Ref: Application Number 2026/62/90666/W (Retaining Wall at 56 Heaton Road Huddersfield)

DRAWING NUMBER: 26/4138/A3

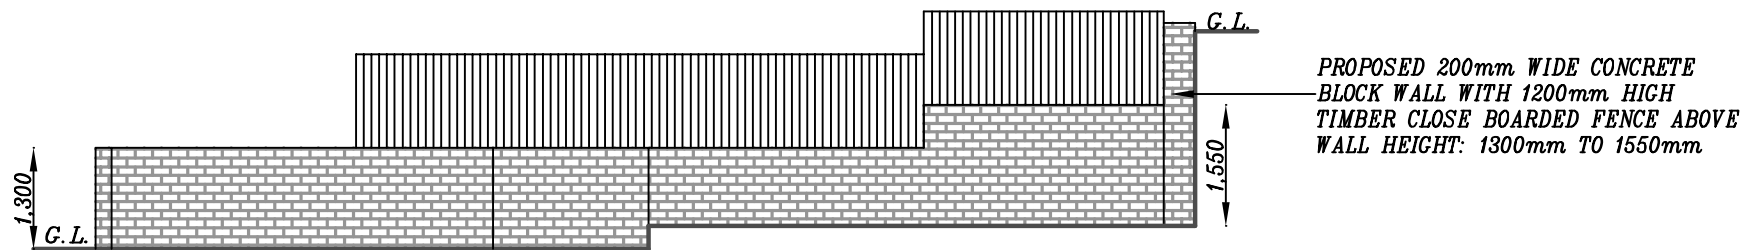
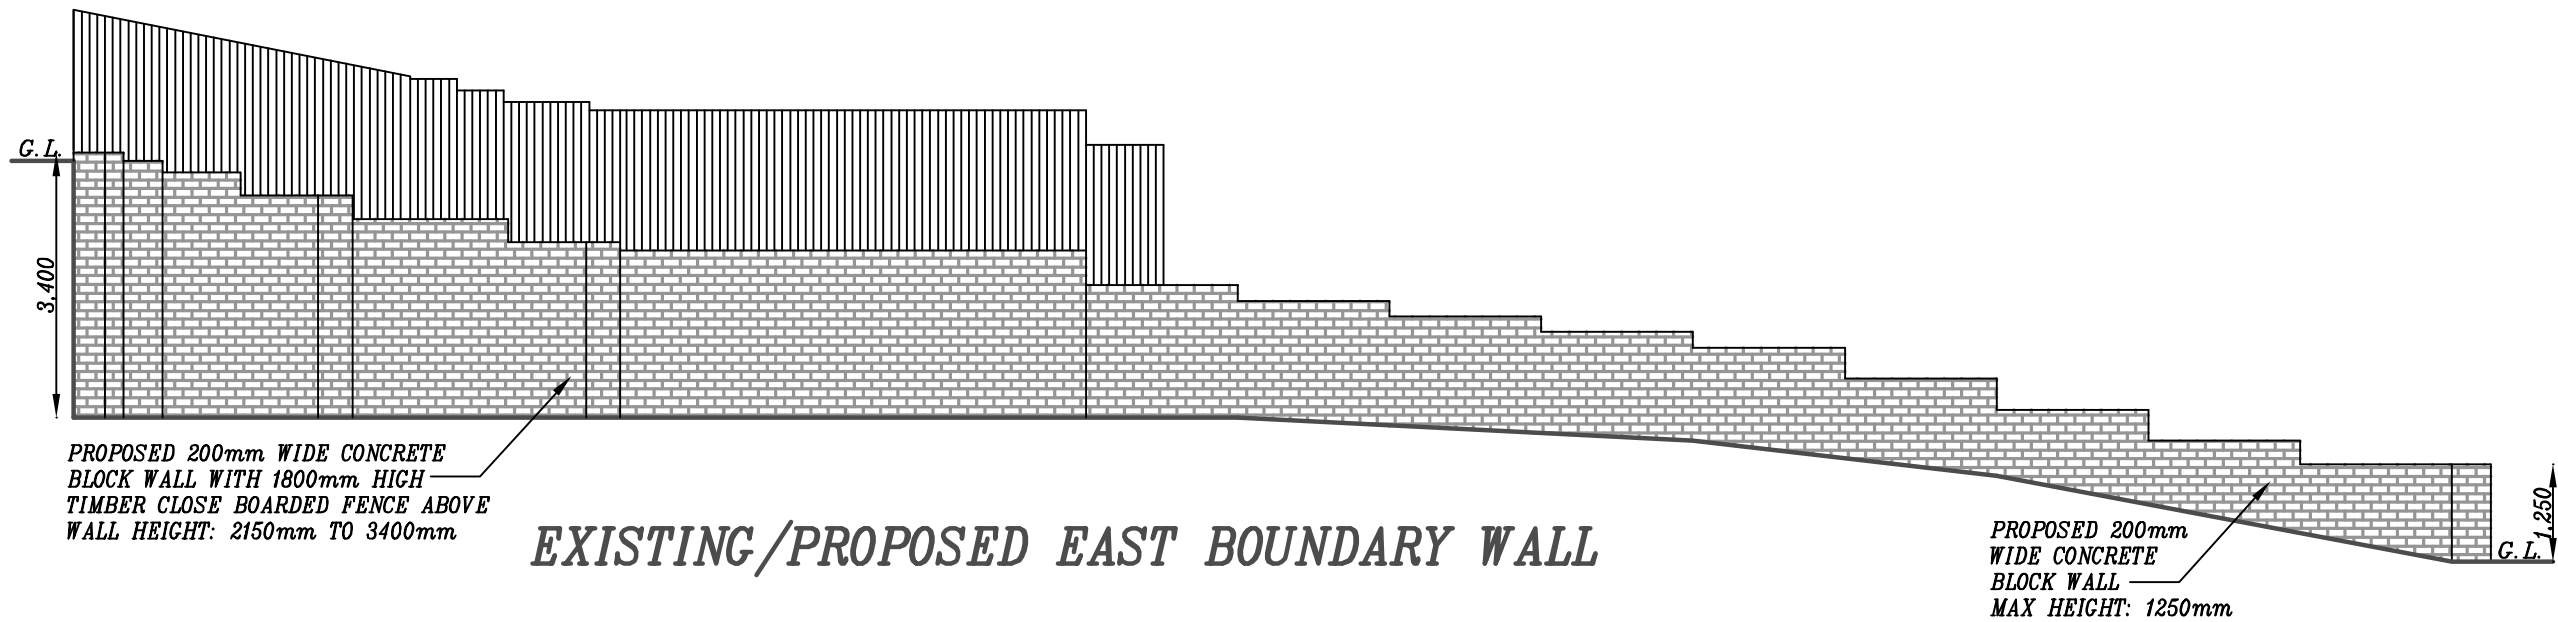
10. With regards to the retaining wall, I am unsure where to begin. To be brief, no evidence of building regs approval or detailed drawings so by default not safe. To my untrained eye, I cannot see movement joints, no weep holes, no back-fill, no geotextile membrane, no erosion control, no wall ties, no rebars, no backfill, no water pressure prevention works and not keeping with the local area. This is definitely the wall that Jack built but wearing a blindfold and with one hand tied behind his back. This wall is hideous. I do not understand how the residents are not embarrassed by such a monstrosity.
